FW: Application K/3/26/PD - Potato Barn, Kingston Lane

Many thanks for your dialogue both on the phone and via email this week. As advised, we have given great consideration to the curtilage clauses under Part Q3 as part of the preparation of this revised prior approval. Part of this revised scheme was to address comments on gardens etc which were raised under the original application, so we're keen to emphasise our thought process on this issue.

**Proposed Site Plan
(Current application K/3/26/PD)**

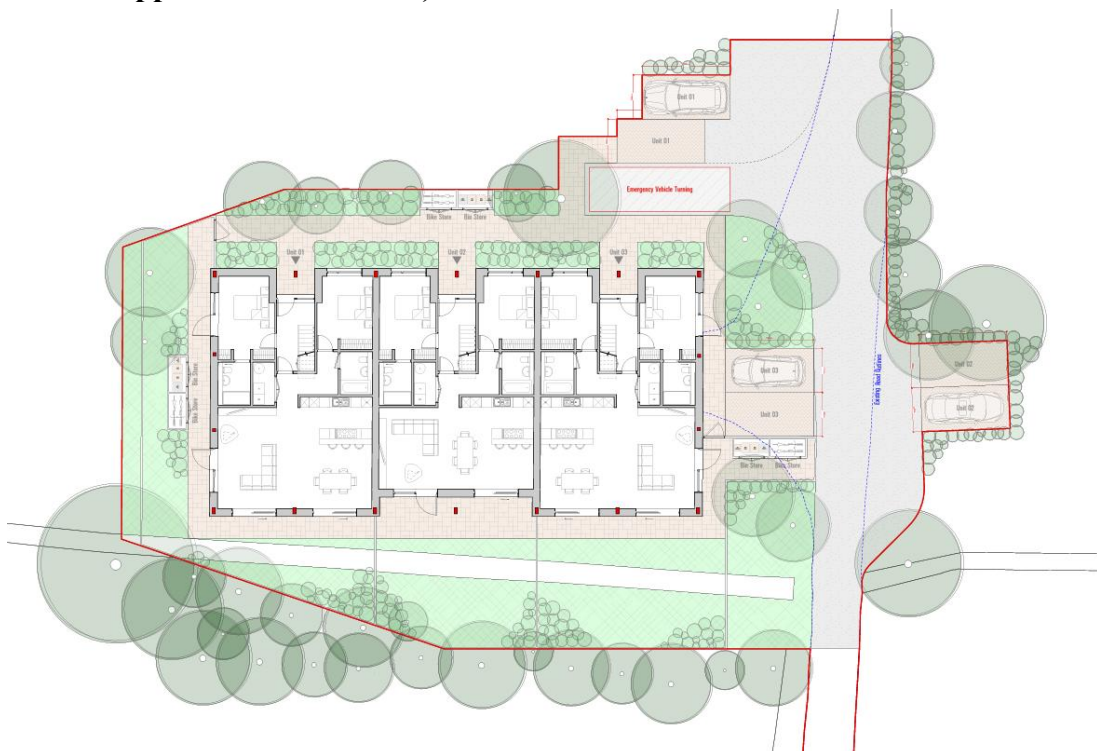
I have taken a further look at the plans as discussed, and I have some concerns about the size of the curtilage proposed with the conversion. I don't believe that all of the land shown as the curtilage of the property, including the proposed gardens which are located on the other side of the drainage ditch, forms part of the curtilage of the existing building. Q.3 (1)(a) states that all land within the curtilage must be "closely associated with and serving the purposes of that building". The area of land where widening of the road and additional parking is proposed to the east of the existing road also does not appear to be linked to the building. Even assessing the curtilage purely in terms of area, and excluding the access road, the area of the curtilage is larger than the area occupied by the building by some way, and so does not comply with Q.3 (1)(b).

On this basis, the conversion of the building and the curtilage as shown would not be permitted development. Unfortunately, the location plan cannot be amended under this application and I would be objecting to the application for this reason. If you would prefer to withdraw the application, please let me know.

I attach a drawing which shows, in blue, our interpretation of the agricultural curtilage, which responds to Q3(1)(a). The drawing also includes the footprint of the existing building and a hatched red area of curtilage for Q3(1)(b).

The area to the south of the building is land which is immediately surrounding the building and forming one enclosure which aligns with the southern tree line and boundary fence to the field to the south – as shown in the attached photo. The ditch is not the defined enclosure in this case.

Based on the above evidence and attached plan, the curtilage shown on the blue line is land which immediately beside and around the building on a former agricultural building and is closely associated with and has served the purposes of that building in the past. On this basis Q3(1)(a) is met.

Without prejudice, the red hatched area on the attached plan shows that the curtilage will be less in footprint than the building. This demonstrates that the area of land around the building is no larger than the land area occupied by that building and on this basis accords with clause Q3(1)(b).
